**Ref No:** F2020/00663

Application No: SSD-10831778

**Re: Randwick City Council submission on the State Significant Development SSD-10831778 – Sydney Children’s Hospital Stage 1 and Children’s Comprehensive Campus Centre (SSD-10831778)**

1 EXISTING SHADOWS - JUNE 21 - 9AM
1:1500

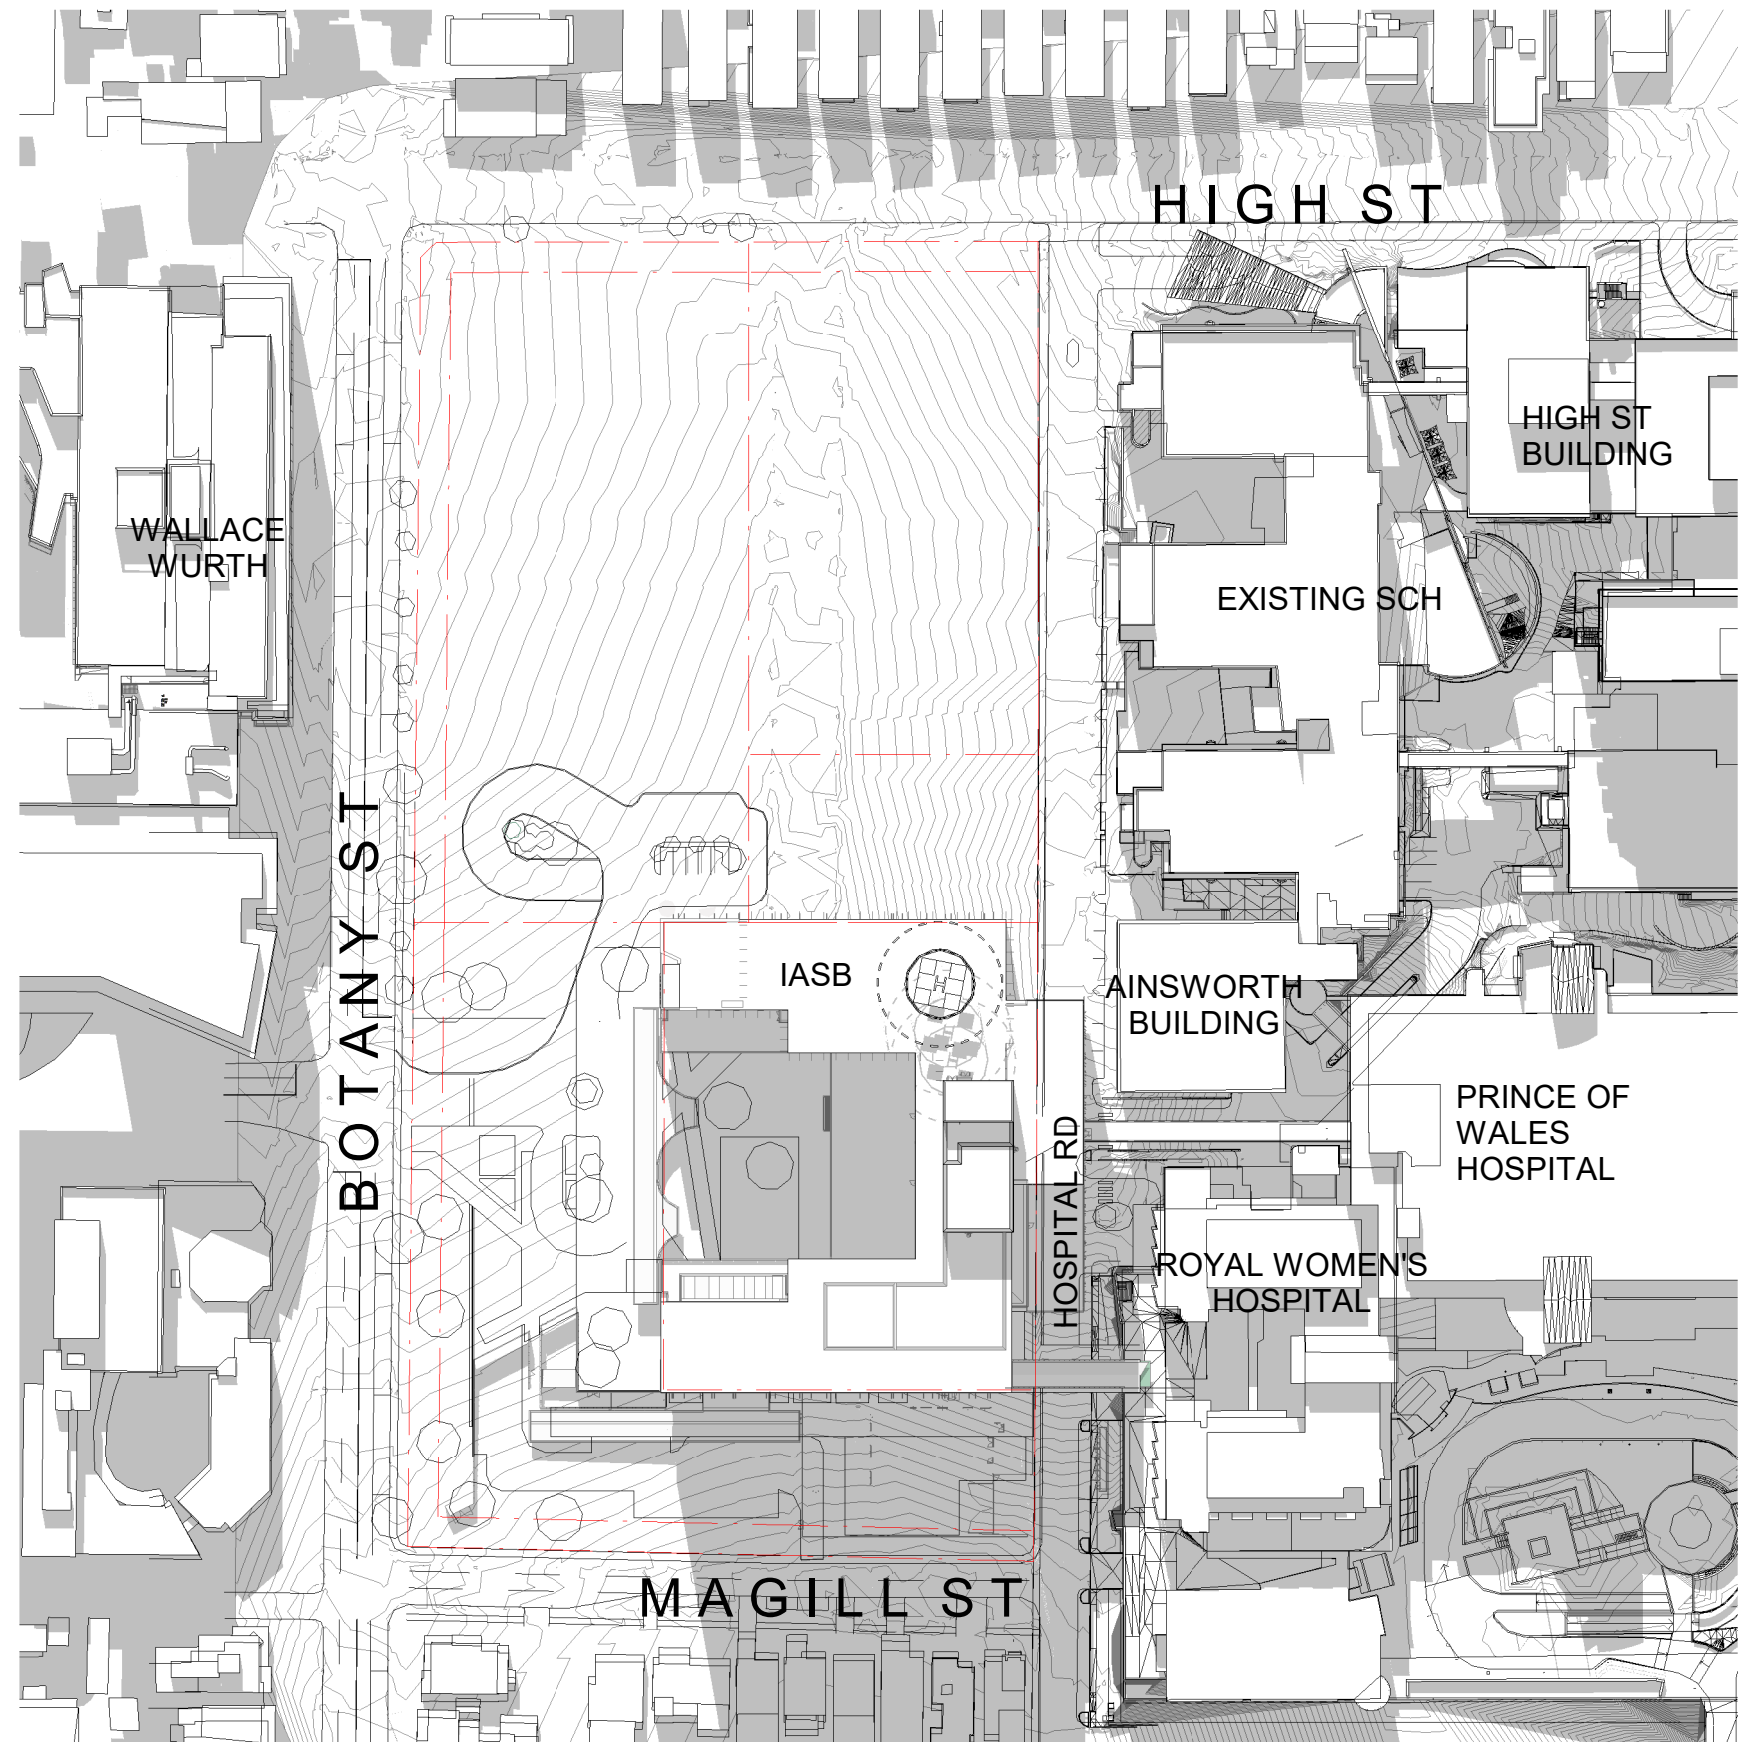
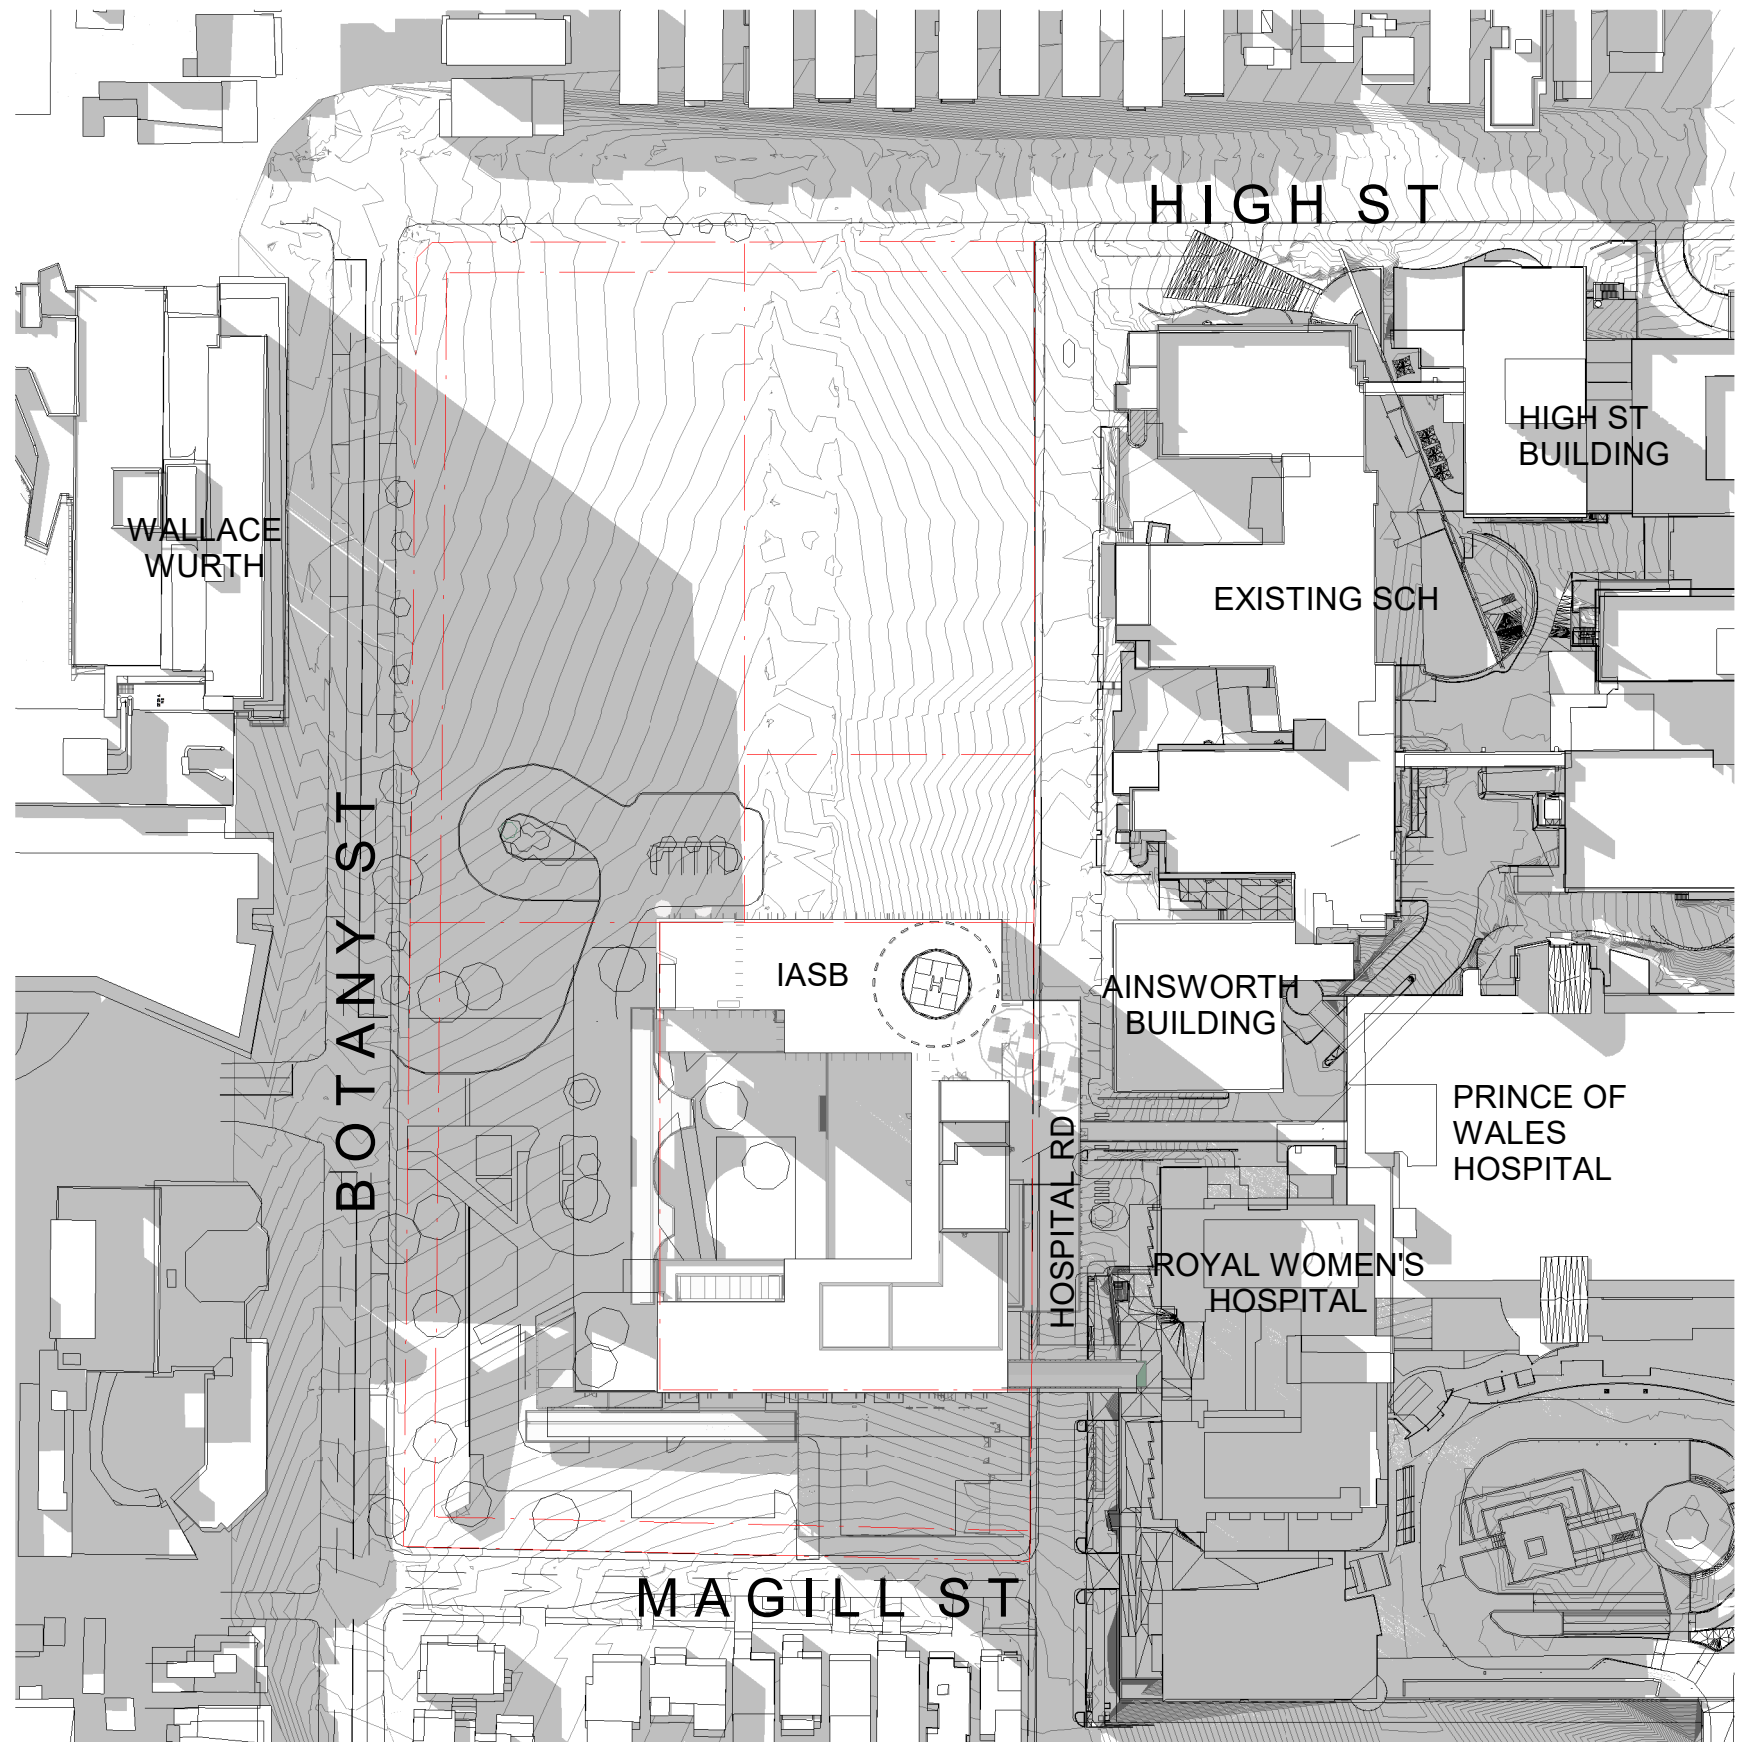
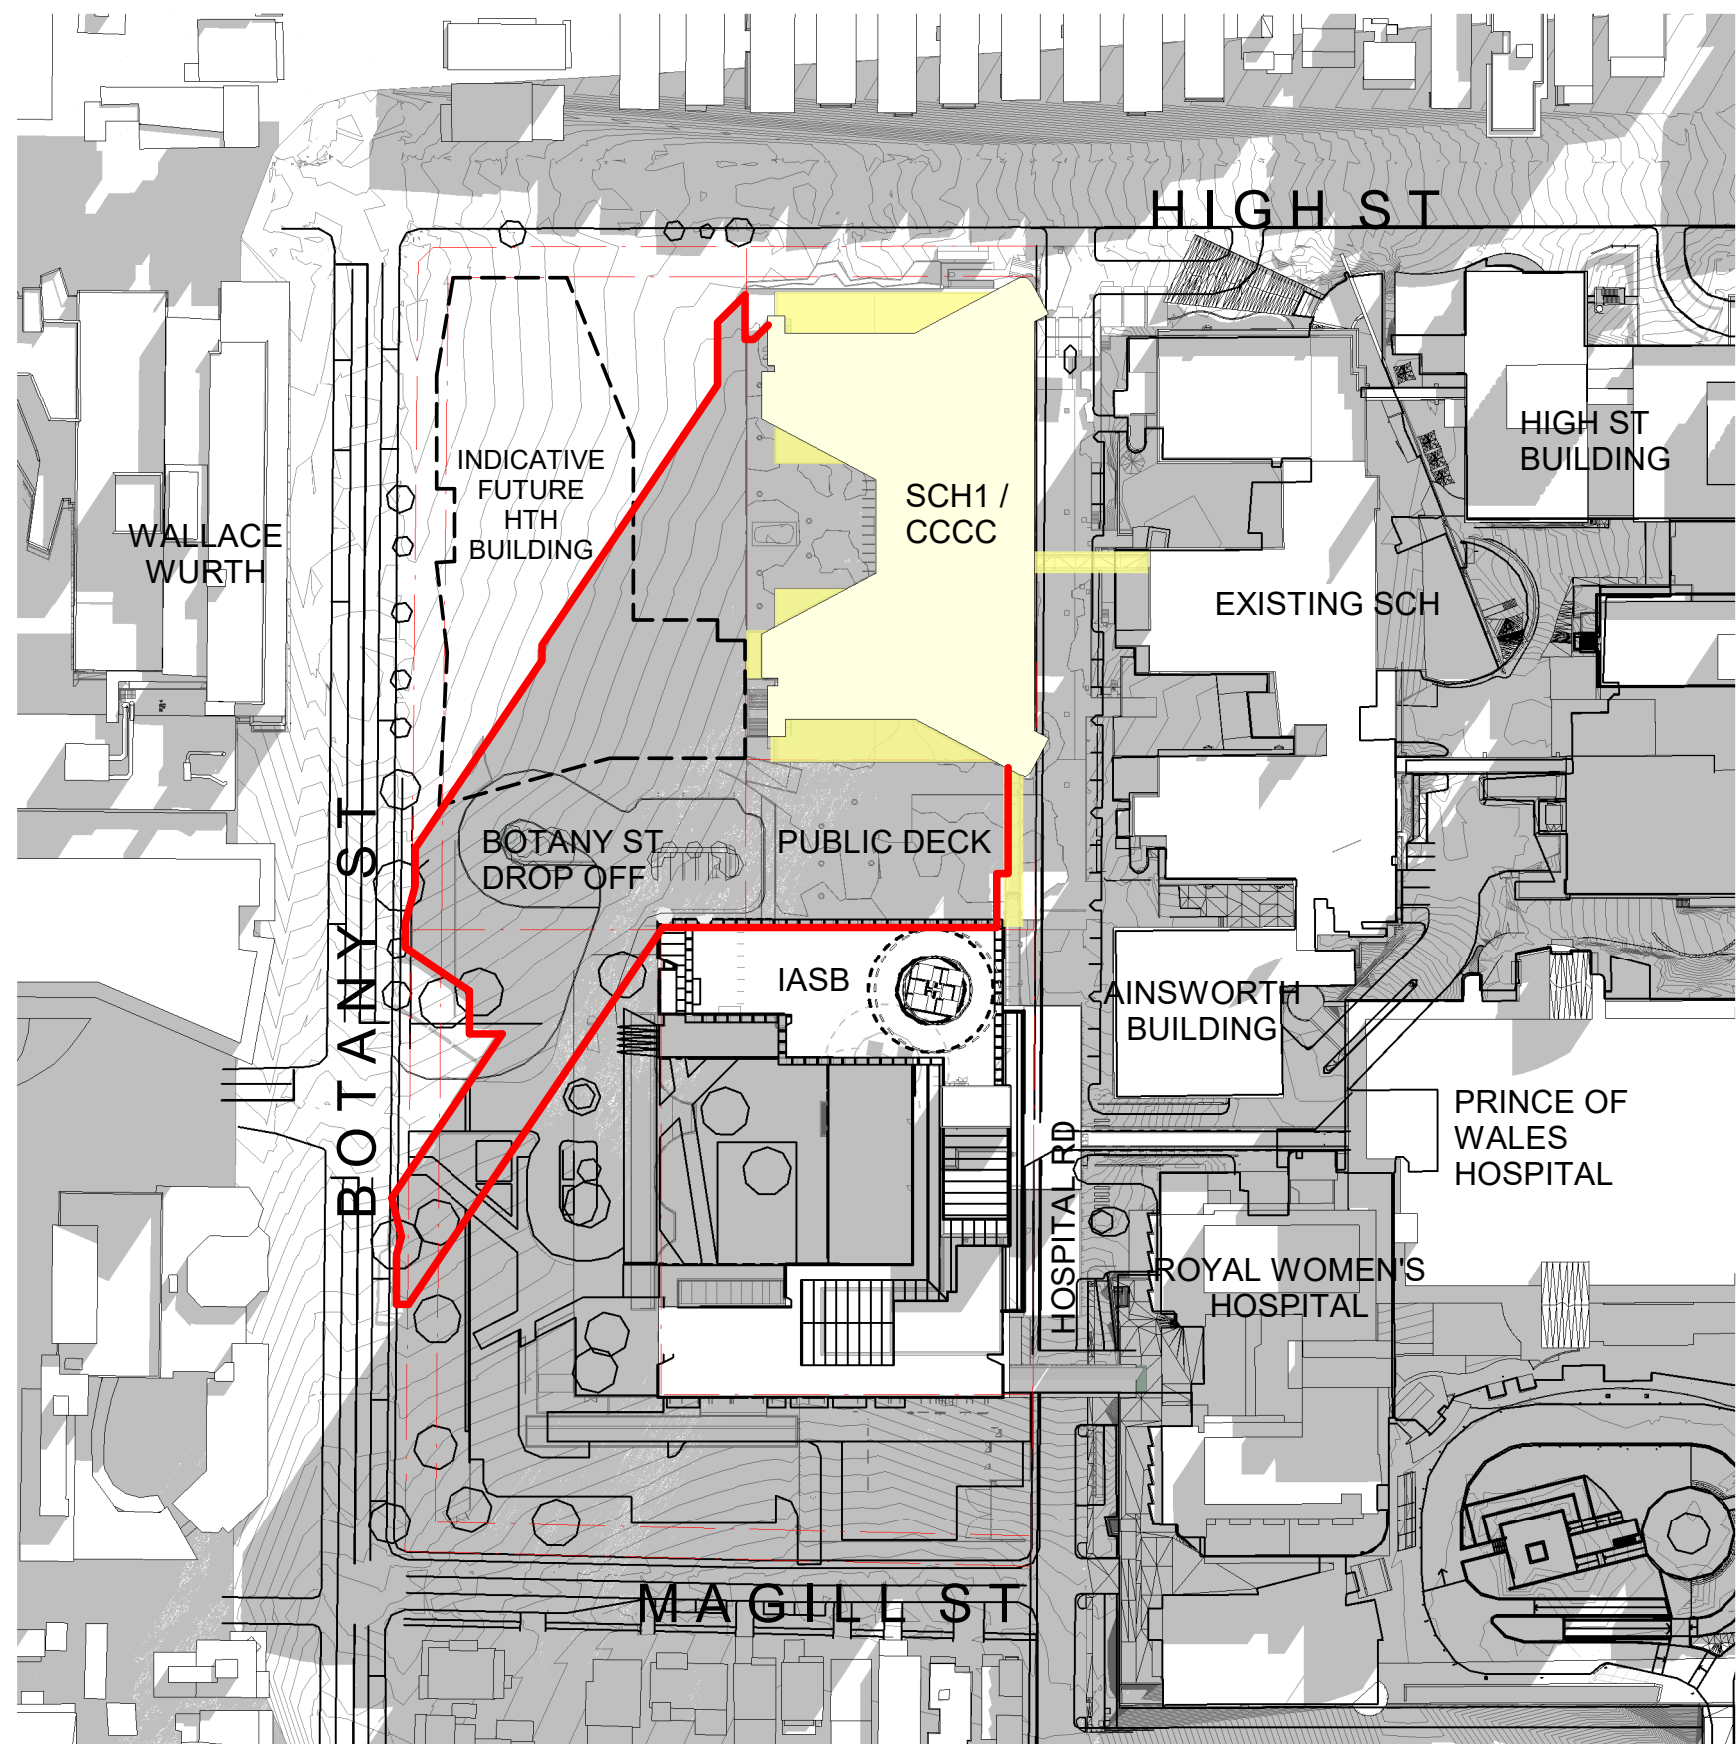
31. The proposed building will significantly overshadow the proposed children's play area through most of the year and particularly during the winter months, resulting in an inappropriate location for a children's play area. A location that receives sunshine, with a northern aspect would be preferable. Locating the play area to the north of the building, within sight of the proposed café, would provide a safer and more welcoming location. Alternatively, a north facing play area on an upper level terrace or roof of the building could be considered.

32. The north leg of the building, as proposed, blocks mid-morning sunshine from reaching the plaza. Reshaping and or increasing the height of the undercroft of the north west corner of the building should be explored to improve solar access to the plaza in the mid-morning.
